Arun District Council
Arun Civic Centre
Maltravers Road
Littlehampton
West Sussex BN17 5LF
Planning & Building Control General Enquiries
Tel: (01903) 737756 Fax: (01903) 730442
Dx: 57406 Littlehampton
Minicom: 01903 732765
e-mail: planning@arun.gov.uk
website: www.arun.gov.uk/planning

Application No: BE/48/25/PL
Site Address: Rear of Regal House And Wayside Shripney Road Bognor Regis PO22 9NP
Description of works: 7 No. residential dwellings and associated works including new access. This application is a Departure from the Development Plan and is in CIL Zone 3 and is CIL Liable as new dwellings.

Thank you for your internet representation made on 9th May 2025 which has been recorded as an objection with the comments as follows:

Drawn by BW	Approved by DF	Date 04.03.21
Scale 1:500 @ A3	Job No R-21-0021	
Drawing No R-21-0021-001	Rev C

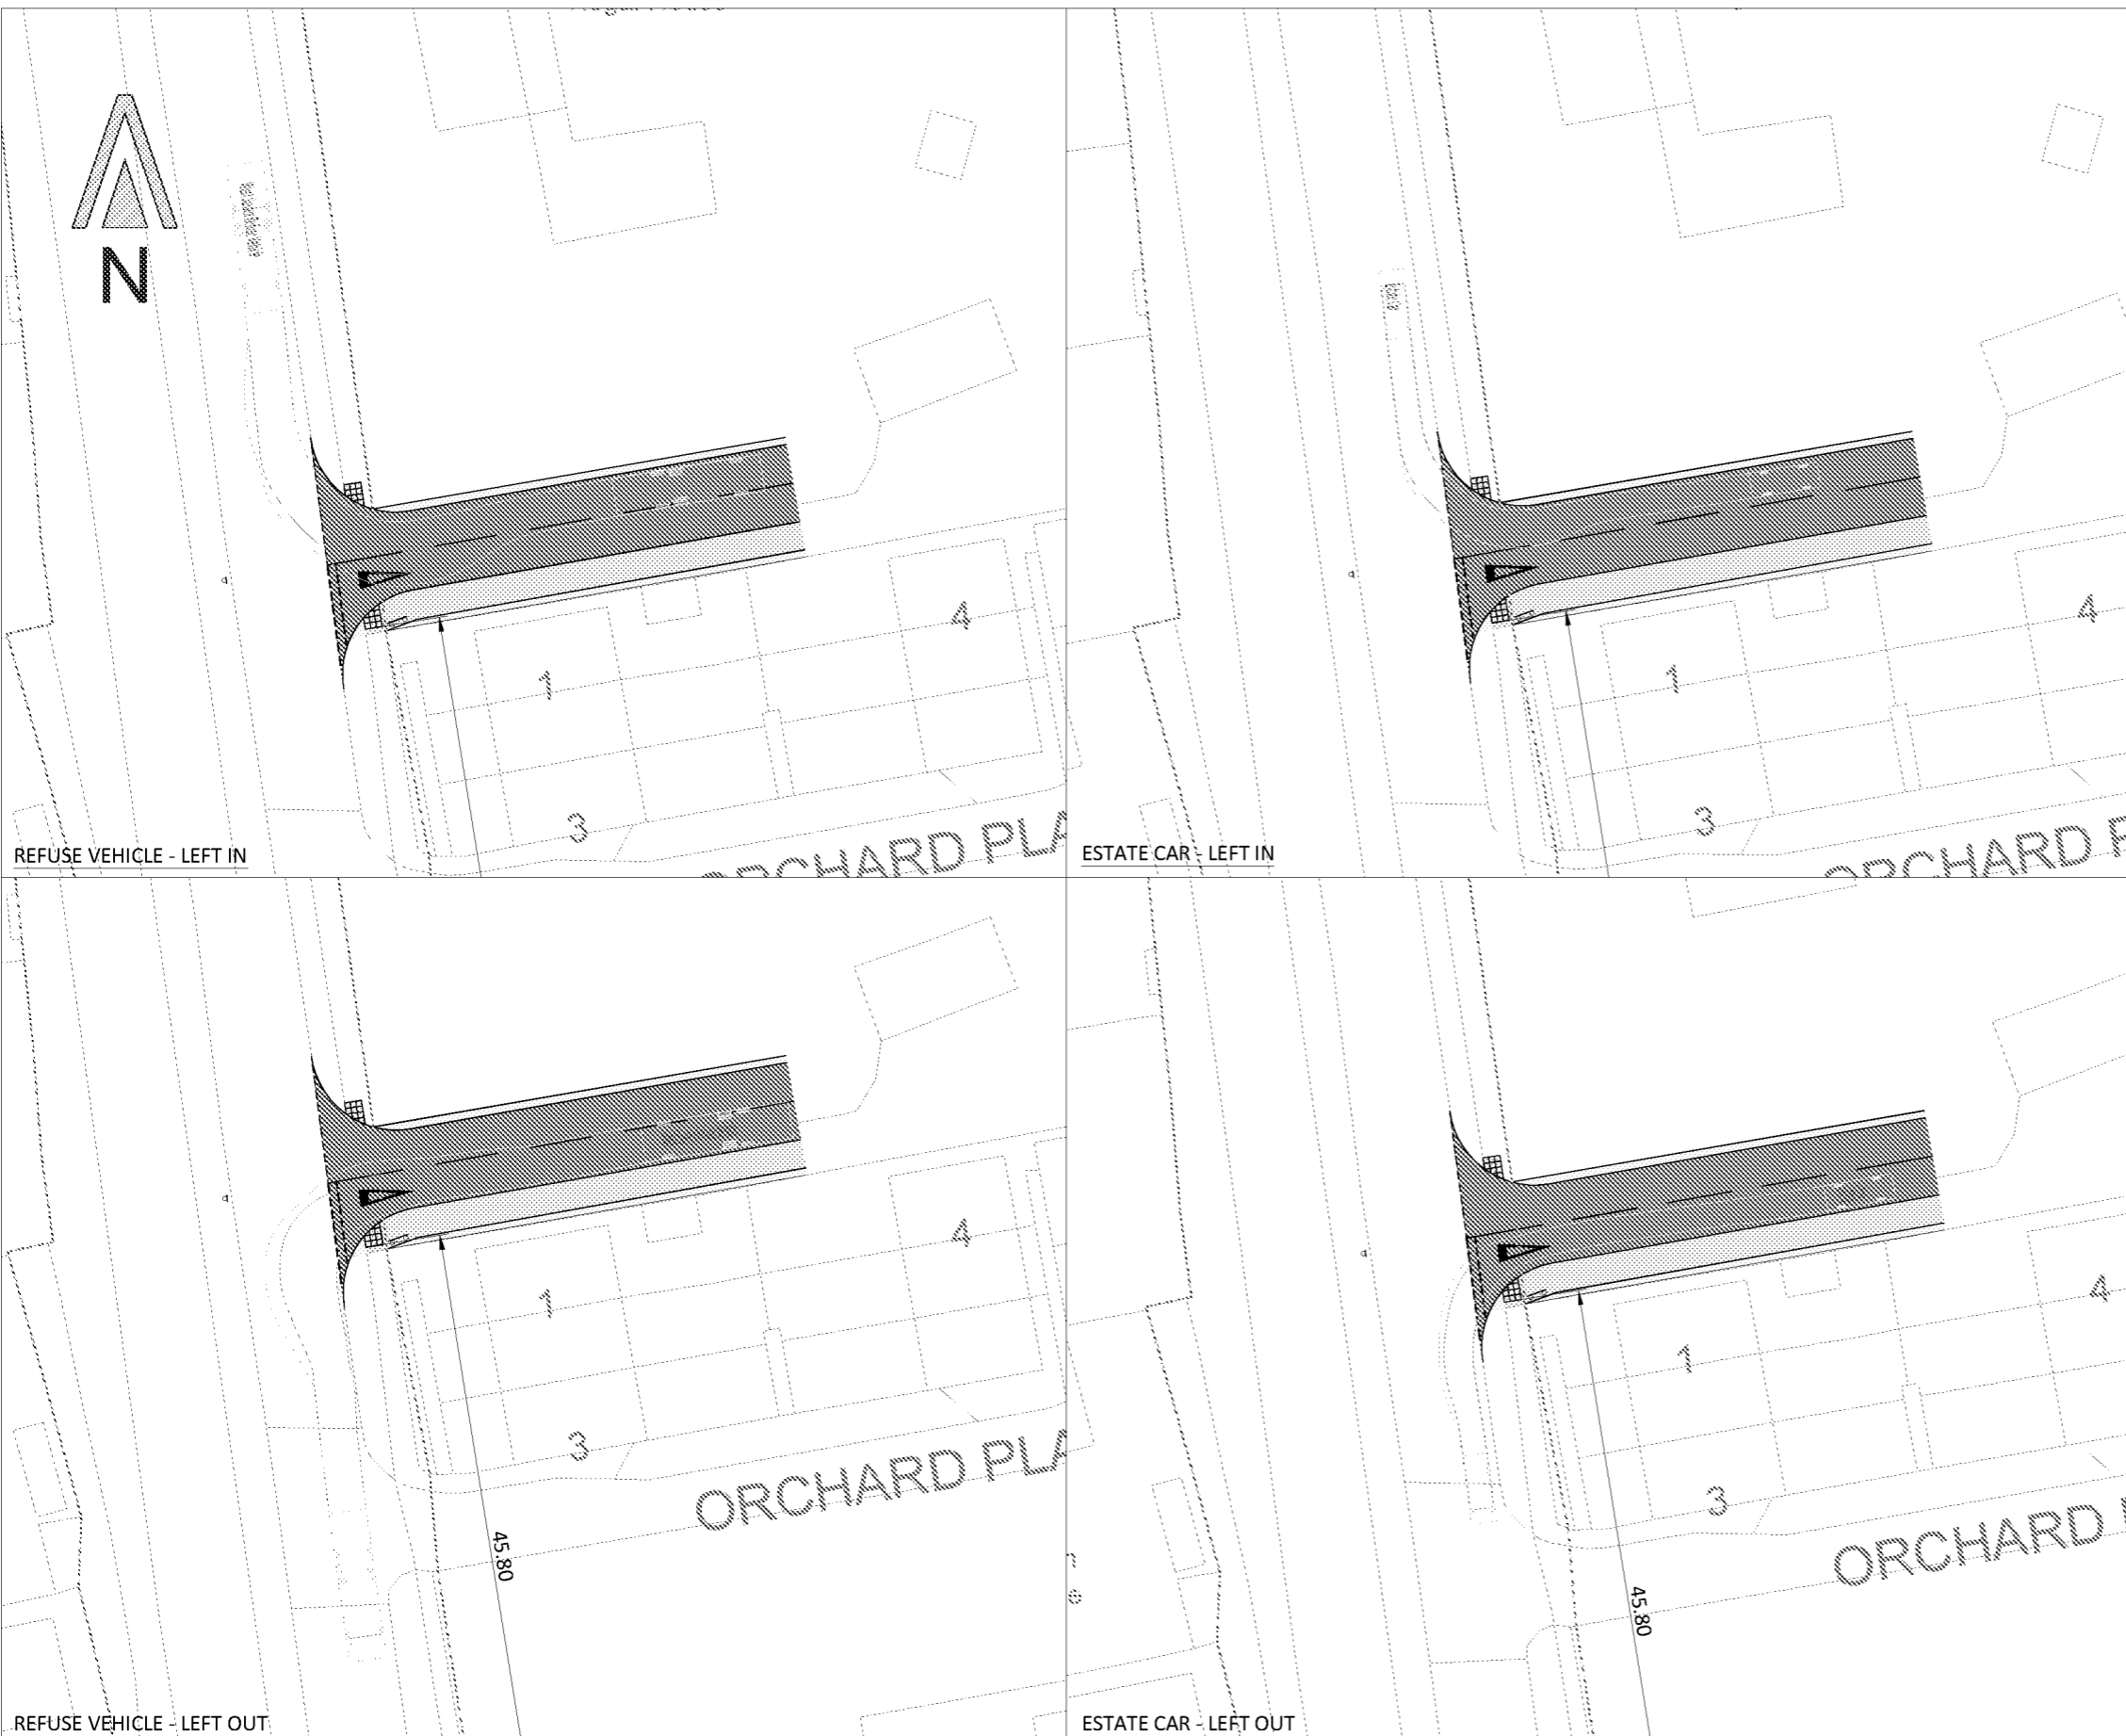
OBJECT for the following, highway safety, the Parish Council feel the access road into the site is not wide enough nor provides adequate visibility to accommodate two vehicles, such as a car and delivery lorry, to pass along it safely. They also feel the access for this site is too close in proximity to the access at Orchard Place.
